CITY OF PORTLAND BUILDING PERMIT

Job ID: 2012-02-3351-ALTCOMM

Kitchen Exhaust System Checklist and code Provisions

Jeanie Bourke - Re: Vignola hood, 10 Dana, 032-V-001

SYSTEM DESIGNED & BUILT BY  
 SEIDMAN BROS.  
 25 SIXTH STREET  
 CHELSEA MA. 02150  
 617-884-8110

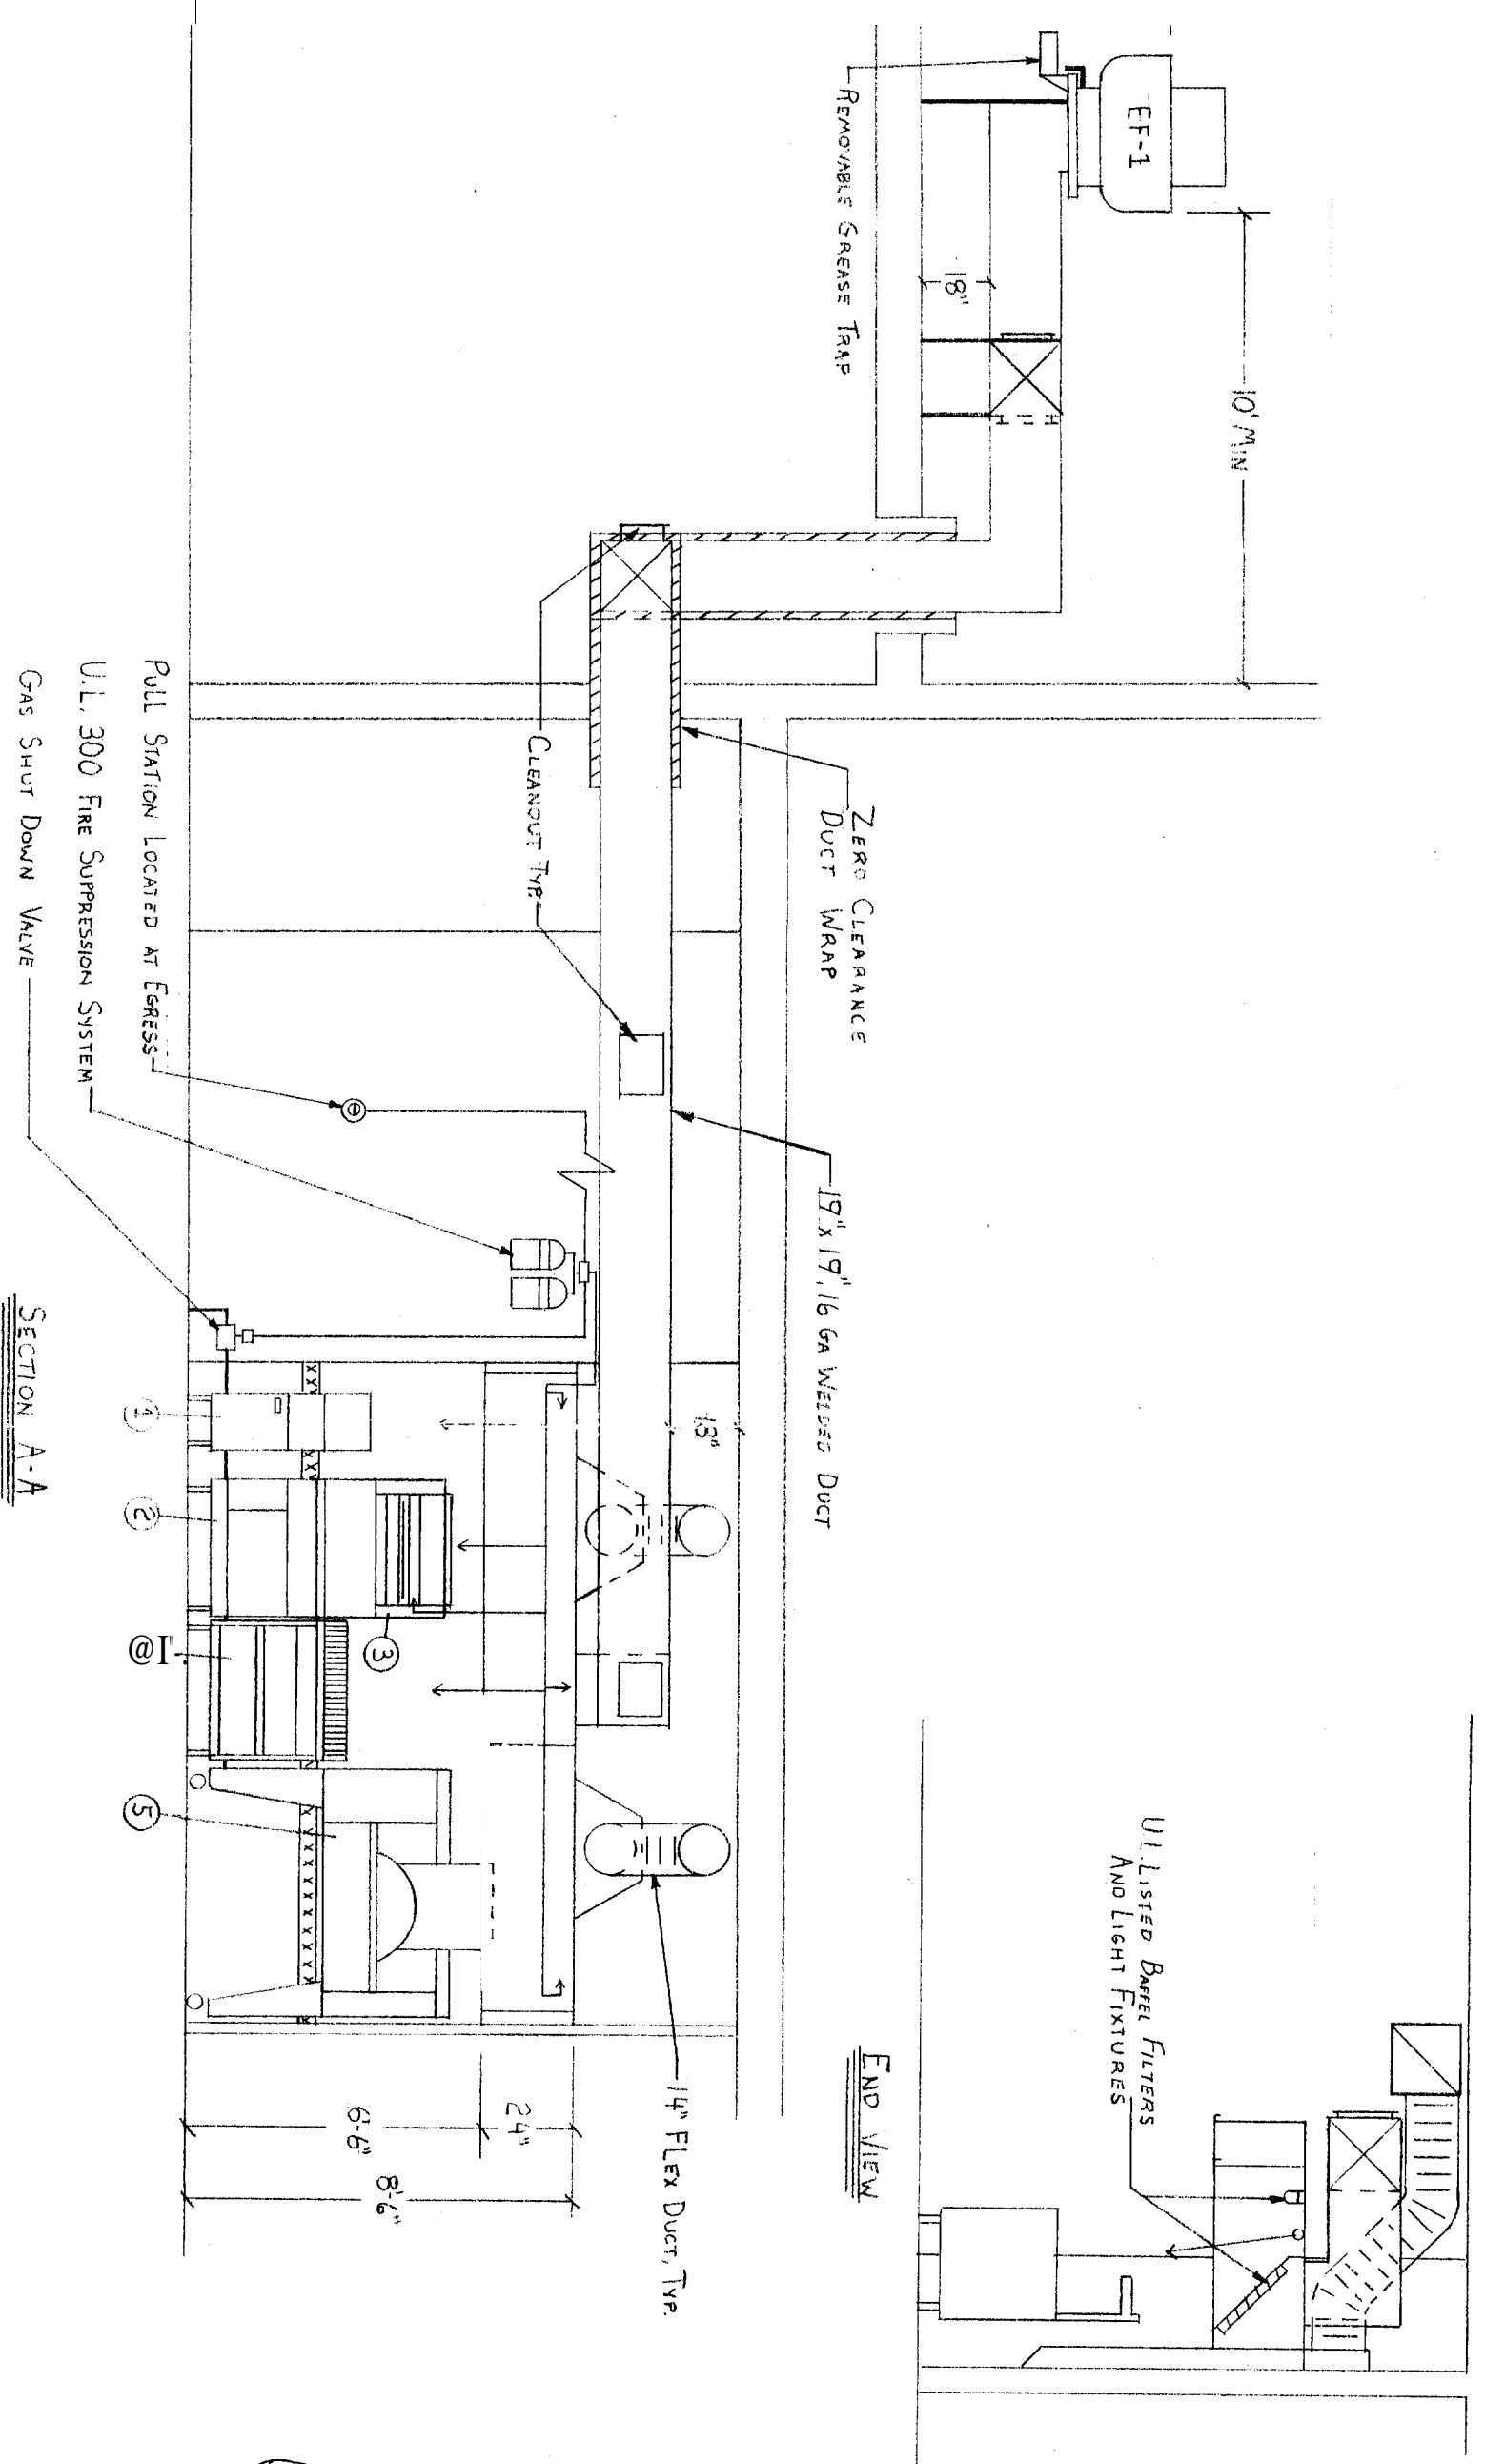
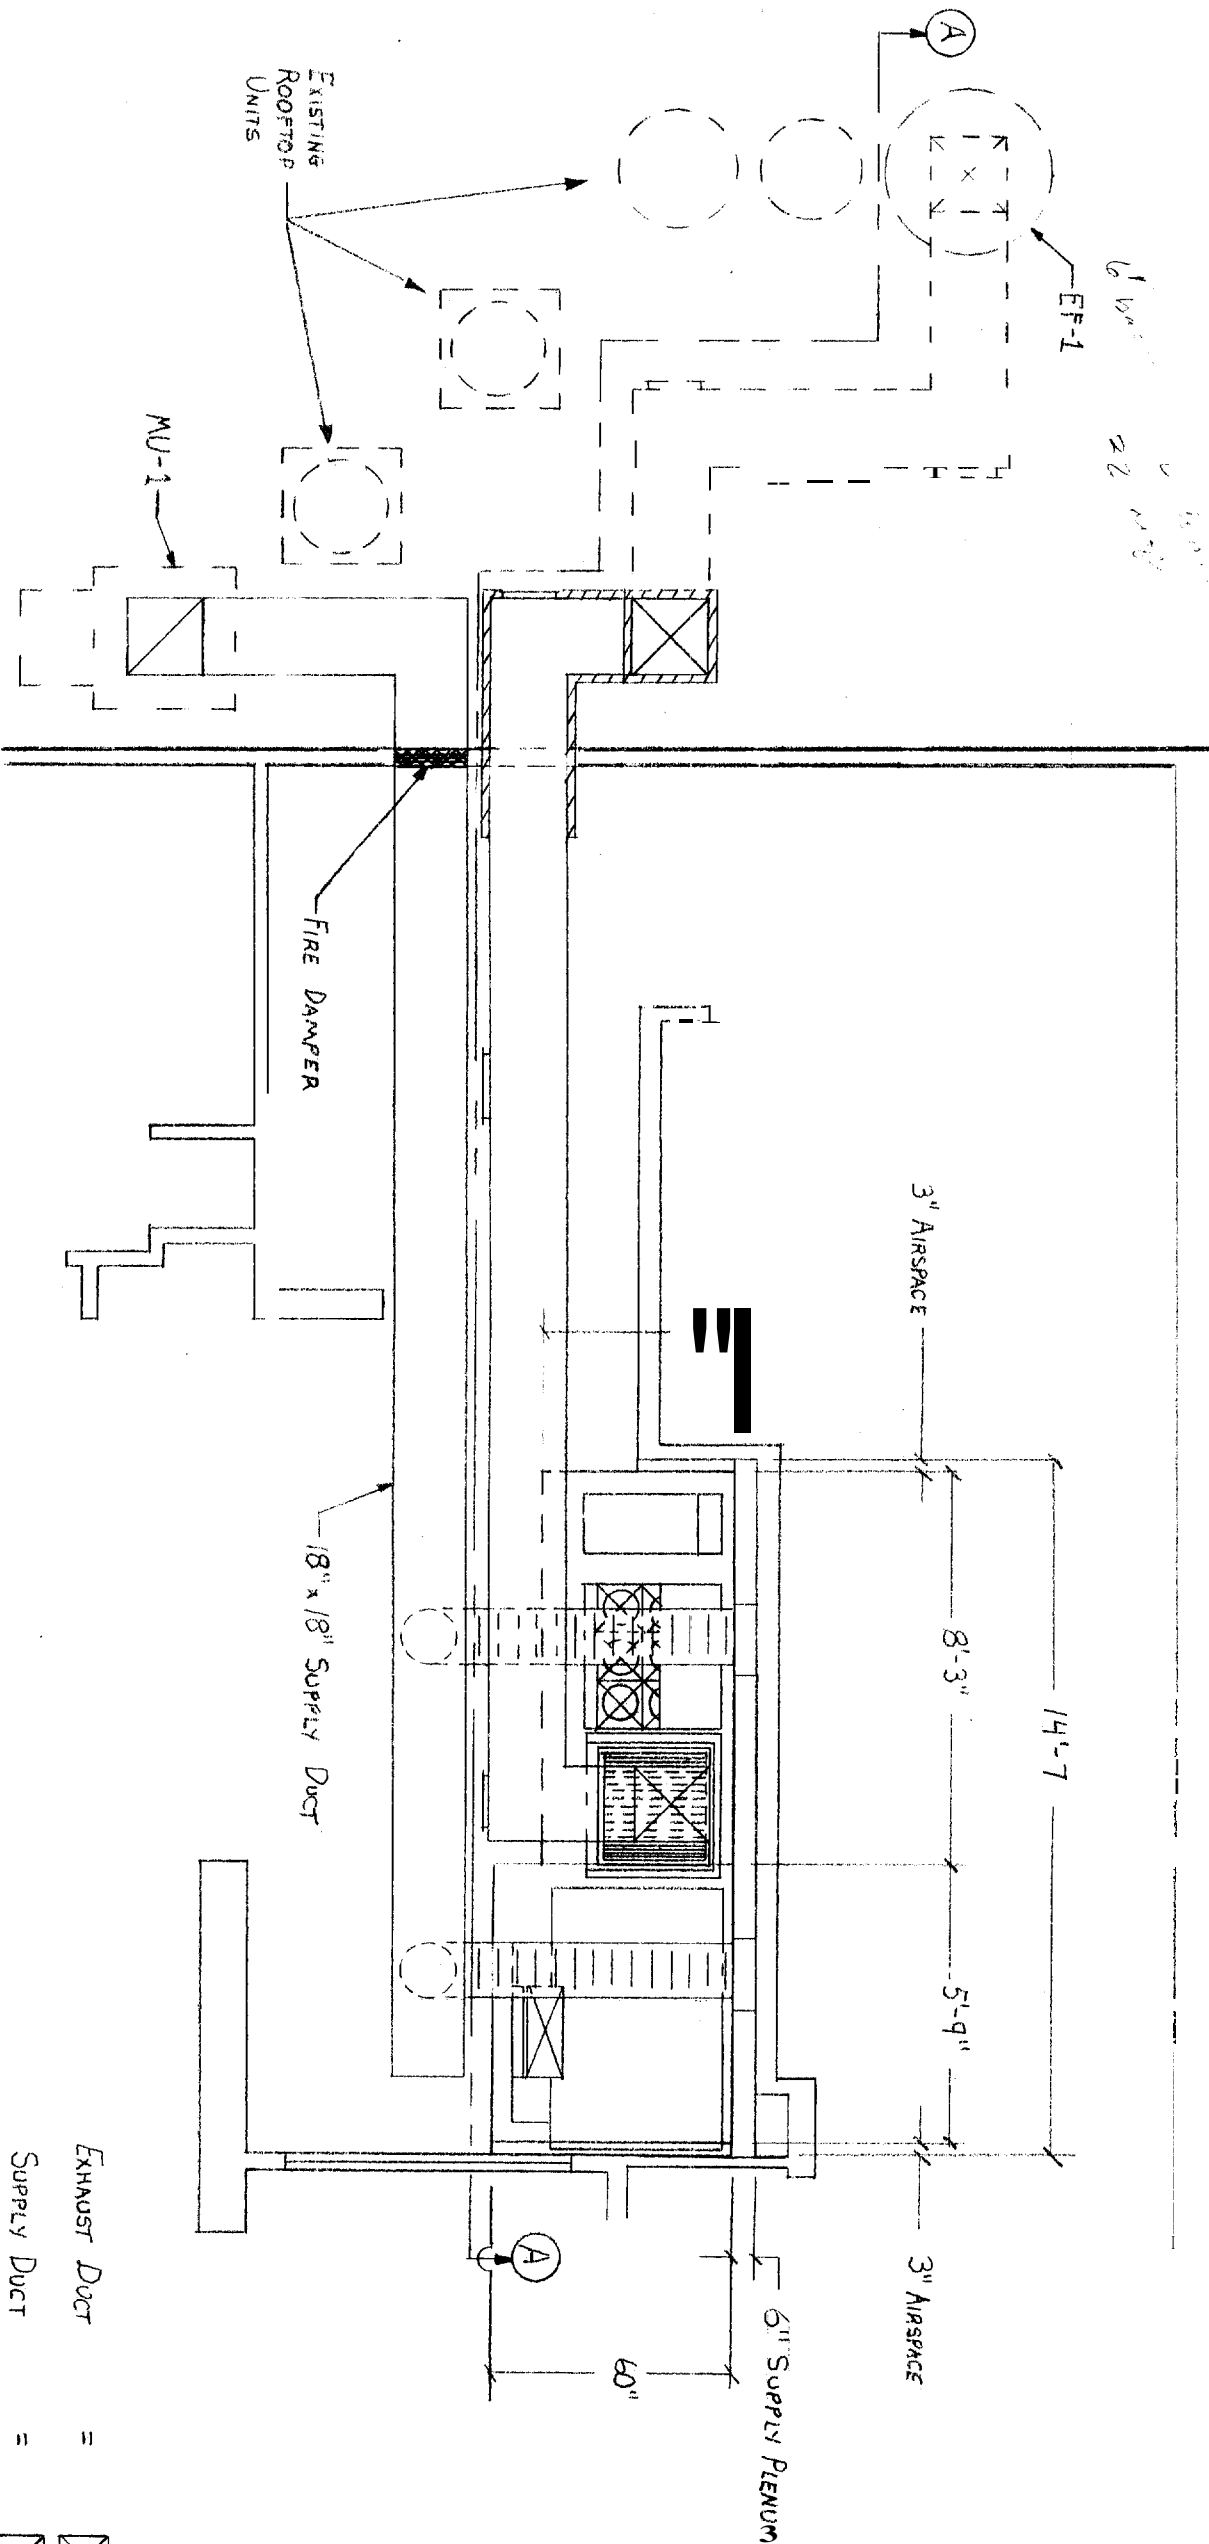
After reviewing NFPA 96 and conferring with the fire Lt. Ben Wallace, we agree that the wood framed wall with 2 layers of fire code gyp does not constitute a limited combustible (Sec. 3.3.35.2) wall and will need clearance reductions as specified in Sec. 4.2.1 & 4.2.3. The structural base or framing cannot be combustible if utilizing the reduction methods.

Please provide a detail showing how this will be compliant.

Also, I forgot to ask you when we spoke this morning about the clearances of the hood to combustible construction. You mention this on the application, however, if the walls are combustible framing, will you be using one of the reduction methods, and if so, please provide this design detail.

As discussed at the stairwell wall we will be adding 1" spacers on the 2 layers of 5/8" with 1" mineral wool and 24 ga stainless steel. At the small wing wall we will have 1 layer of 5/8" and the same spacing detail.

Hello Jeanie,
As per your conversation with Aaron, we will use the reduction method described in section 4.2.3.2 to reduce the clearance to combustibles to 3". Aaron said that you agreed to leaving the existing hood as is.
